REQUEST

Current Zoning: R-9 (CD) (Single Family Residential, Conditional)
Proposed Zoning: N2-A (CD) (Neighborhood 2, Conditional)

Approximately 19.16 acres located west of Nations Ford Road, south of Forest Point Boulevard, and north of Short Hills Drive.

The petition proposes a community of up to 72 multi-family attached residential dwelling units on a vacant, wooded property in the Nations Ford Road corridor.

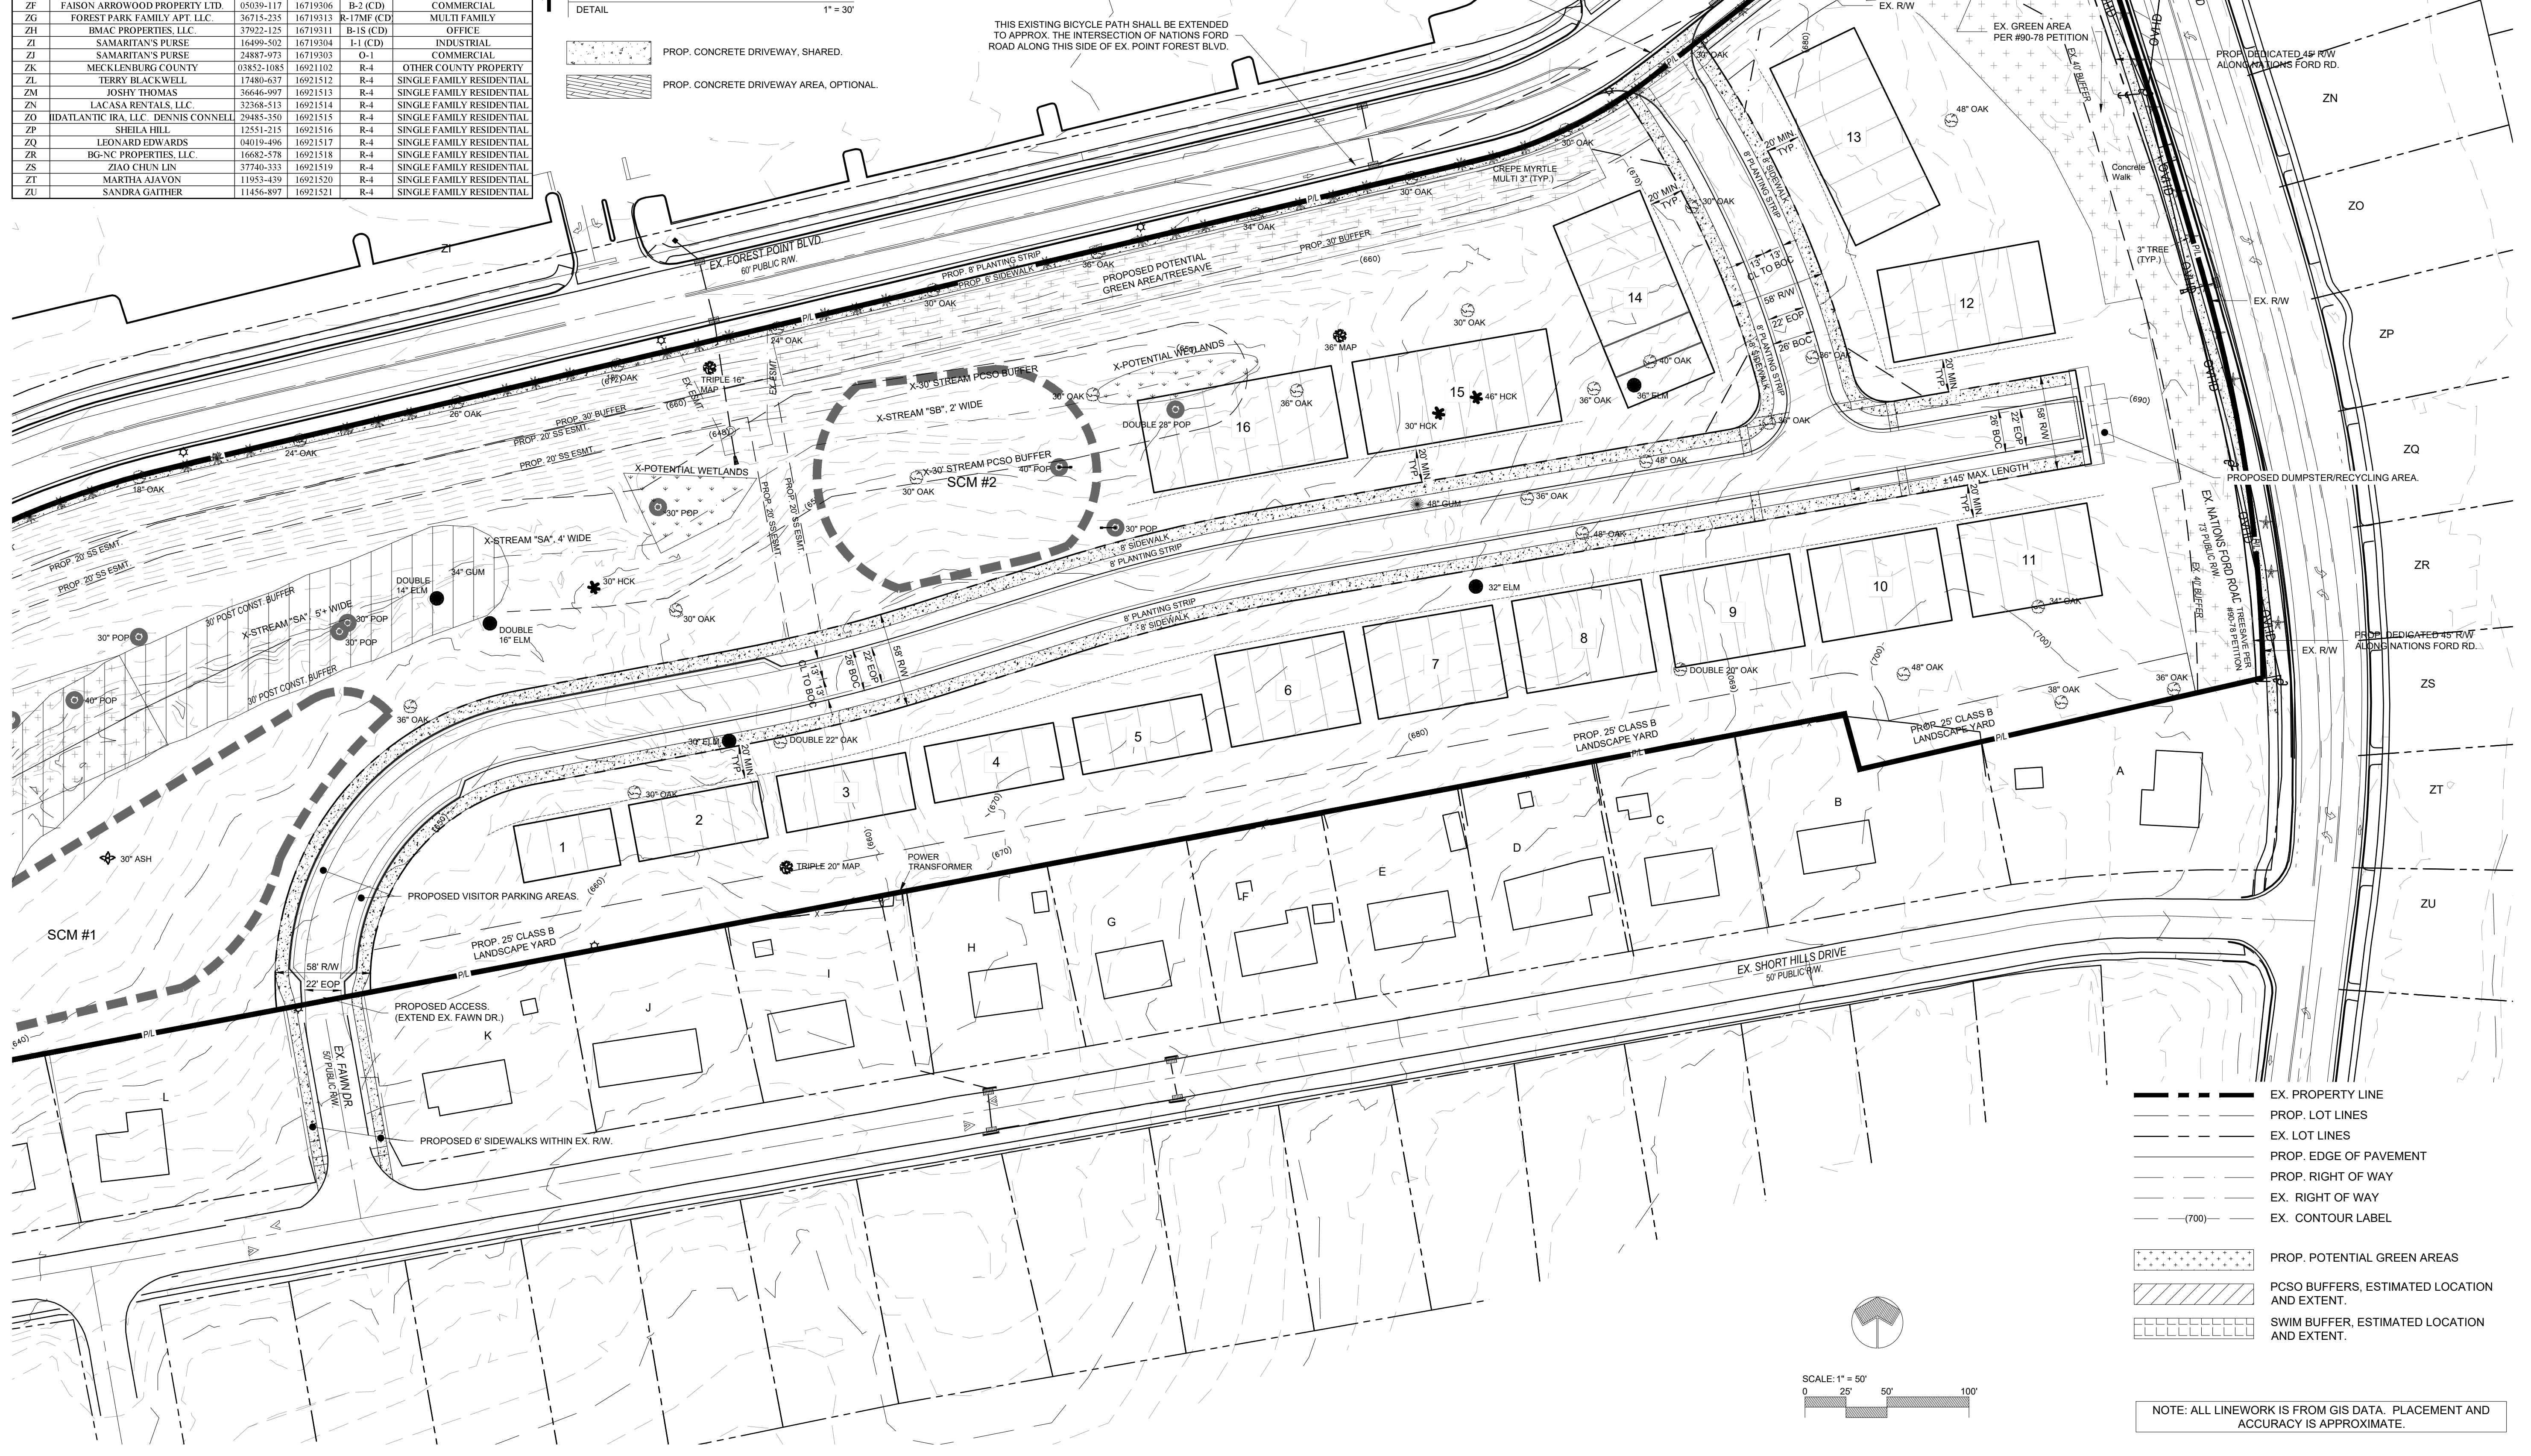
1. ~~From the centerline of Forest Point, label and dimension the ROW and back of curb.~~ **ADDRESSED**
2. ~~Edit note 5.f to reflect 50'x50' sight triangles as opposed to 35'x35'.~~ **ADDRESSED**
